Re: Nusenda Credit Union
6401 Uptown Blvd NE
Traffic Circulation Layout
Architect's Stamp 10-28-25 (H18-D012)

Based upon the information provided in your submittal received 10-29-25, the above referenced plan cannot be approved for Building Permit until the following comments are addressed:

date: 10-31-25
 sheet: A001

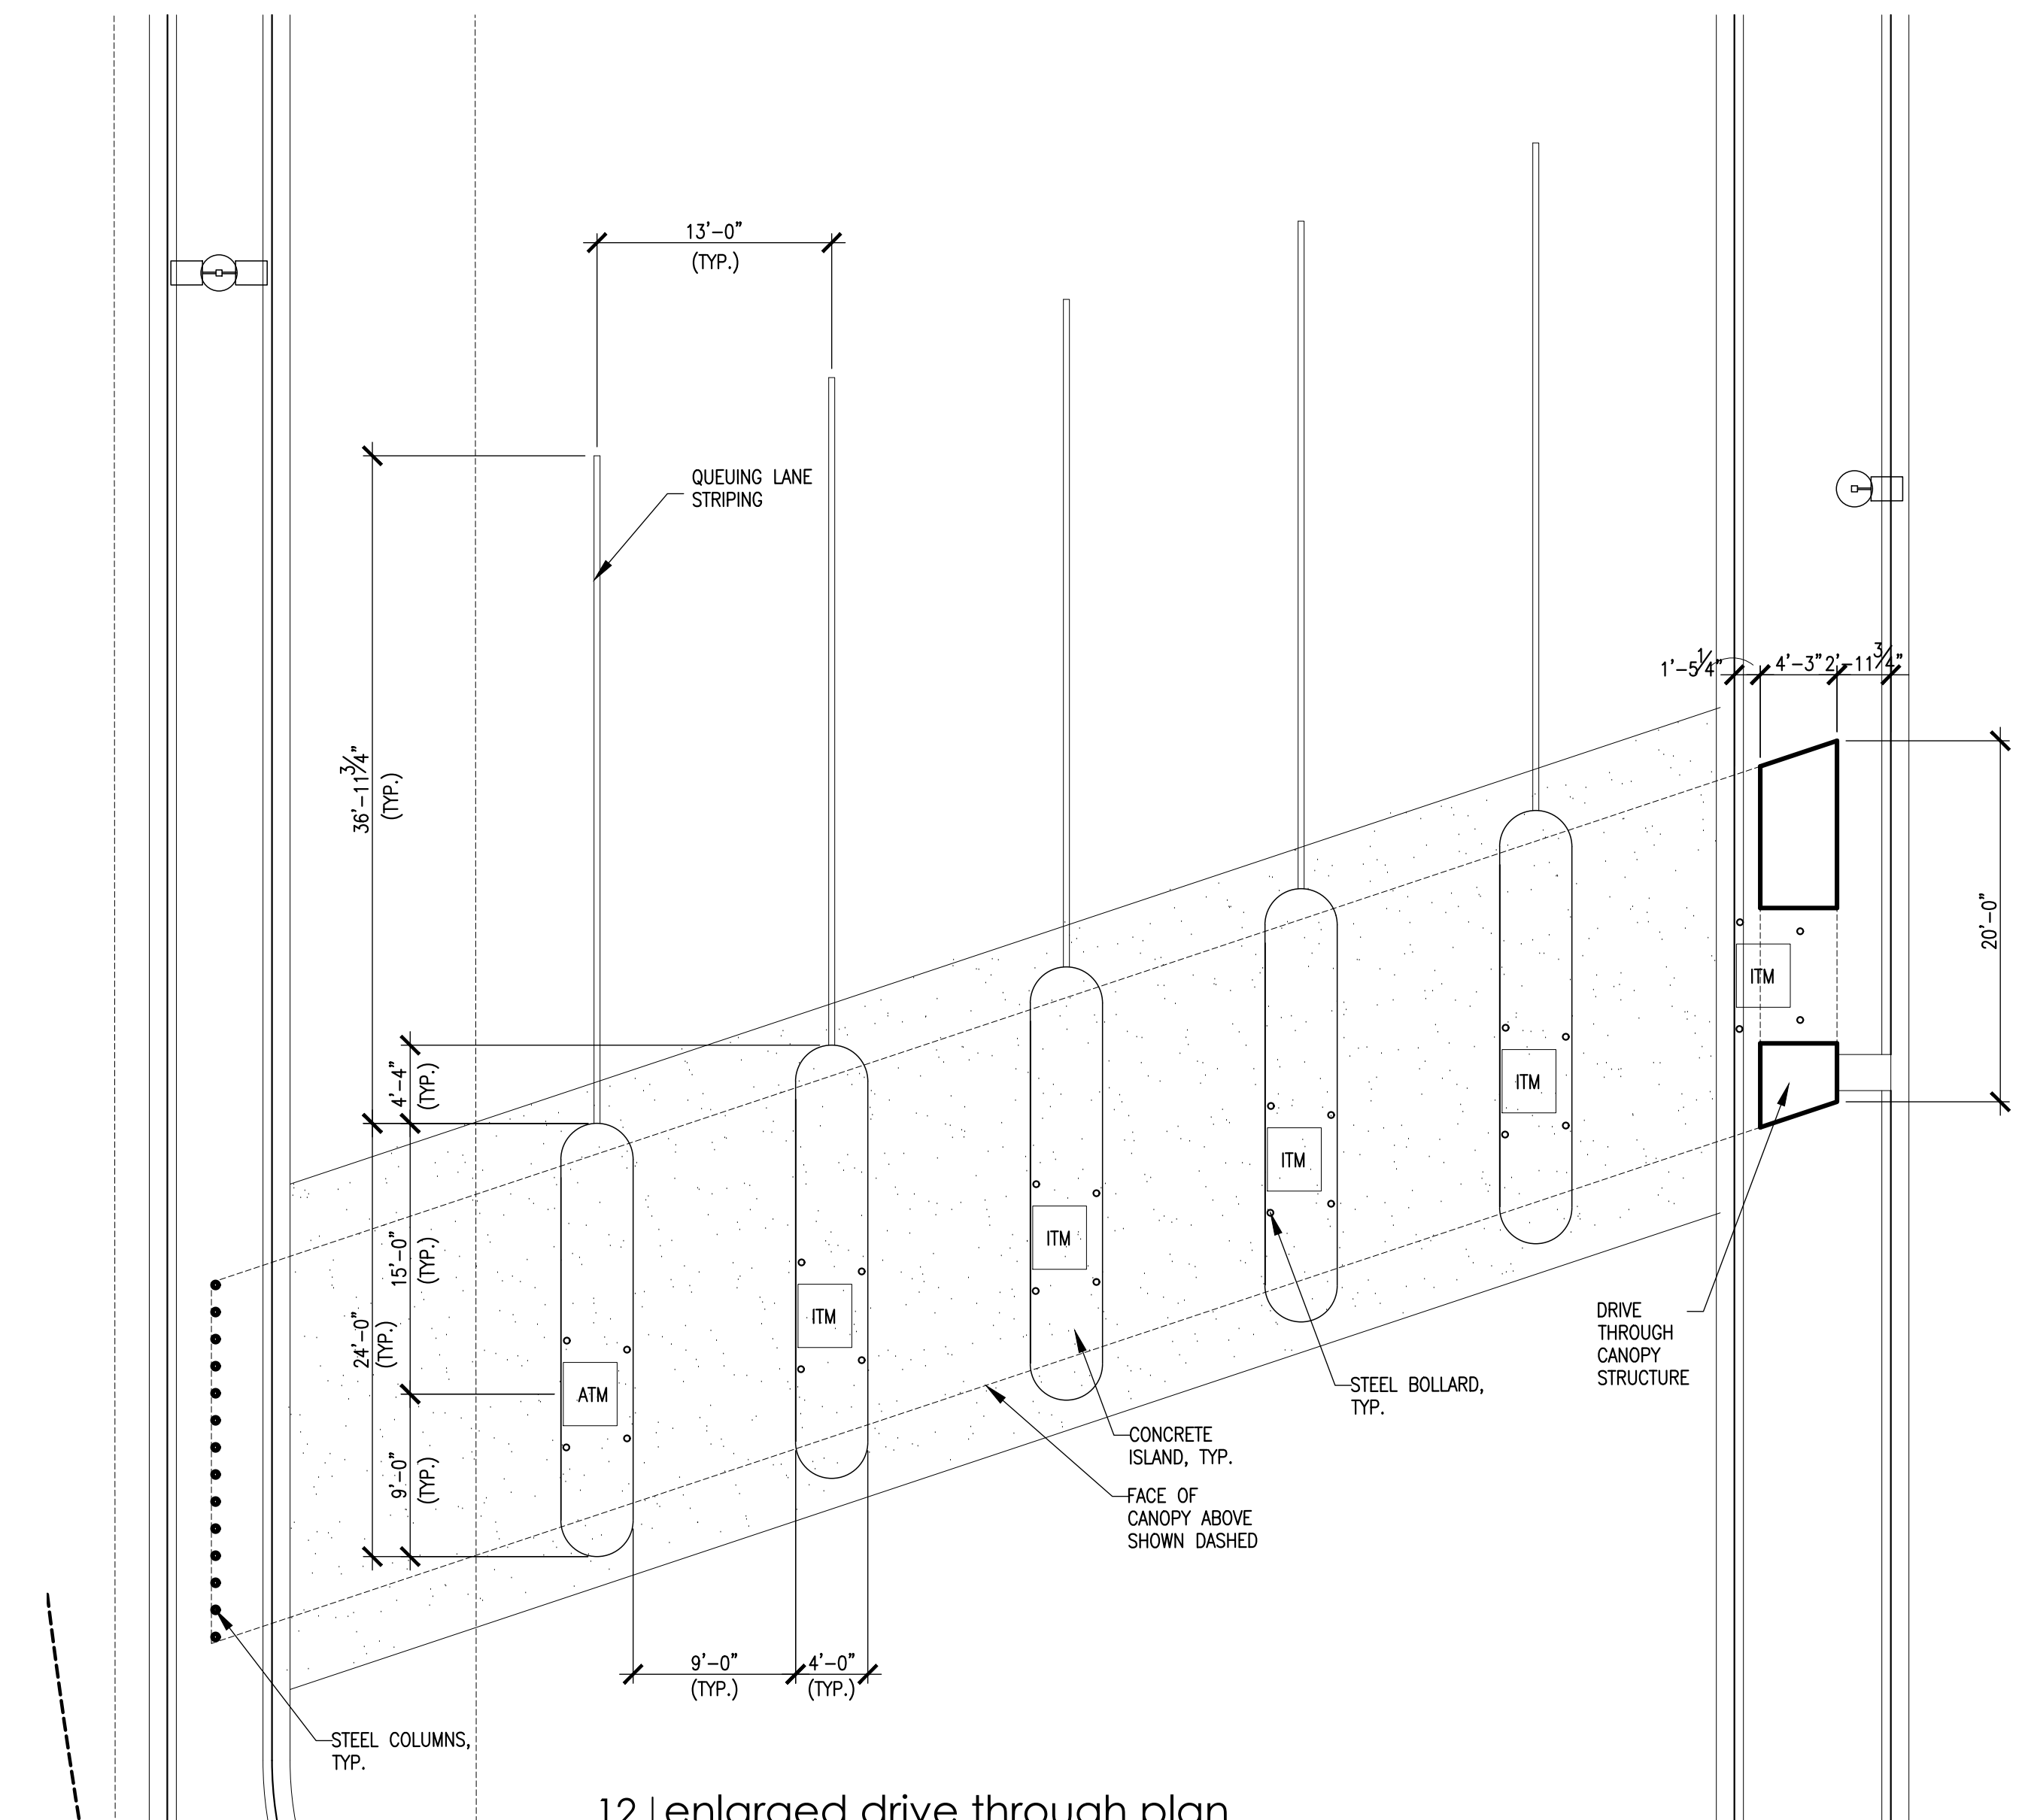
1. List the number of parking spaces required by the IDO as well as the proposed number of parking spaces including bicycle and motorcycle parking.
2. Identify the right of way width, medians, curb cuts, and street widths on Americas Pkwy and Uptown Blvd.

3. Provide shared access agreement with the adjacent west side property, or submit an approved plat demonstrates shared access agreement.
4. Each drive-thru lane shall be 12ft in width.

5. All one-way drives shall have "One Way" and "Do Not Enter" signage and pavement markings. Please show detail and location of posted signs and striping.

6. ADA corner ramp at the intersection of Americas Pway and Uptown Blvd must be updated to current standards and have truncated domes installed.
7. It appears there is a fire hydrant on the sidewalk along Uptown Blvd. Per city requirements and standard dwg 2431, a minimum 4 ft wide clear pathway must be provided around the obstruction.

- The clear sight triangle must be located at the back of the sidewalk for all site accesses.

- Provide a copy of Solid Waste and Fire Marshal approval.
- Add a note stating "All broken or cracked sidewalk must be replaced with sidewalk and curb & gutter." A build note must be provided referring to the appropriate City Standard drawing.
- Please provide a letter of response for all comments given.
